# OXFORDSHIRE COUNTY COUNCIL'S RESPONSE TO CONSULTATION ON THE FOLLOWING DEVELOPMENT PROPOSAL

**Application no:** 22/03063/F

**Proposal:** Erection of 126 dwellings with access from Camp Road, provision of public open space and associated infrastructure

**Location:** Land East Of Larsen Road, Heyford Park

Engineering Plan

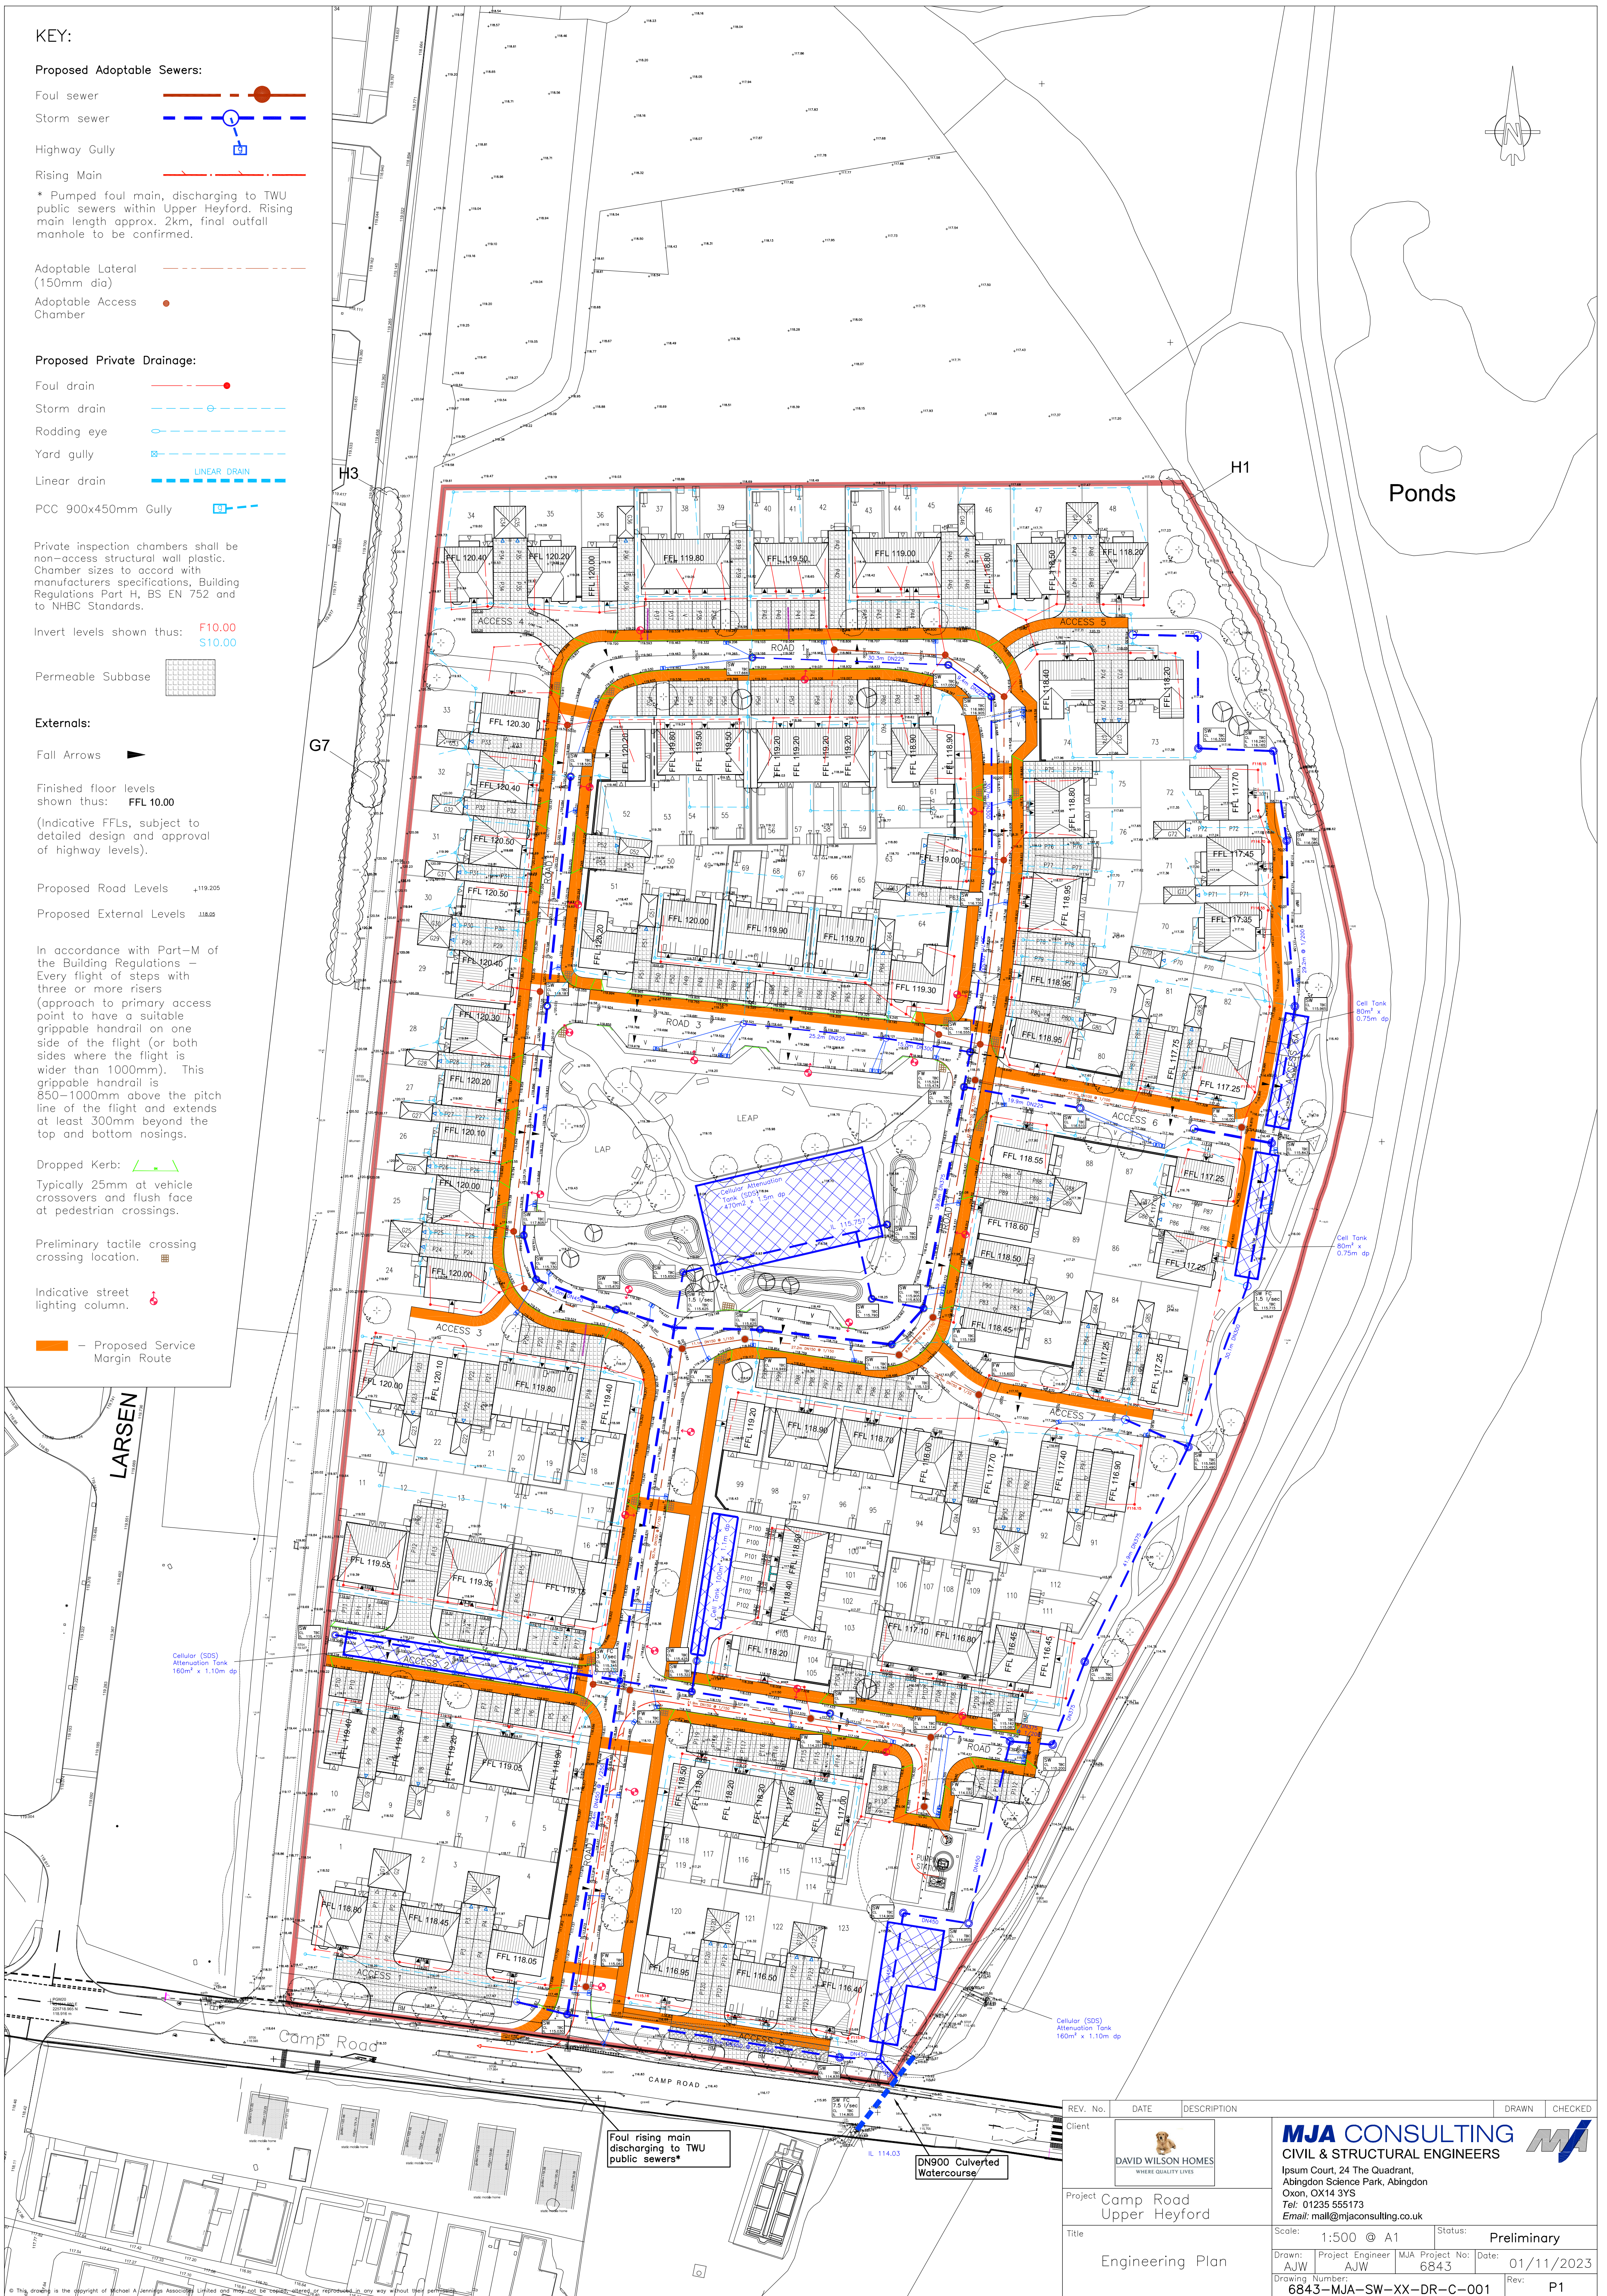
- Where there is not a footway adjacent to the carriageway i.e. a shared surface carriageway, a minimum 800mm maintenance margin is required.
- Adoptable visitor parking bays must be 2.5m x 6.0m
- If roads are to be proposed for adoption they will require a turning head.

- A long section indicating the vertical alignment will be required to determine appropriate carriageway and footway gradients. They will need to be DDA compliant i.e. maximum 1:20 or 5%.

- The Service corridor will need to be a minimum 2.0m wide under the footway or verge.
- There are no visibility splays indicated. Junction and Forward Visibility Splays must be in accordance with the County's Residential Design Guide Second Edition (2015) and dedicated to the County if they fall out of the existing highway boundary.

- Shared surfaces width will be a minimum of 6.0m and a minimum of 800mm maintenance margin is required either side of the shared surface. A blocked paved surface or similar will be required for shared surfaces.

- Foul and surface water manholes should not be placed within the middle of the carriageway, at junctions, tyre tracks and where informal crossing points are located.

- Trees must not conflict with streetlights and must be a minimum 10 metres away and a minimum 1.5m from the carriageway. Trees that are within 5m of the carriageway or footway will require root protection. Given the number of trees indicated it would be helpful that the proposed street lighting is provided as trees will have to be located at least 10 metres away to ensure the streetlights can perform effectively.
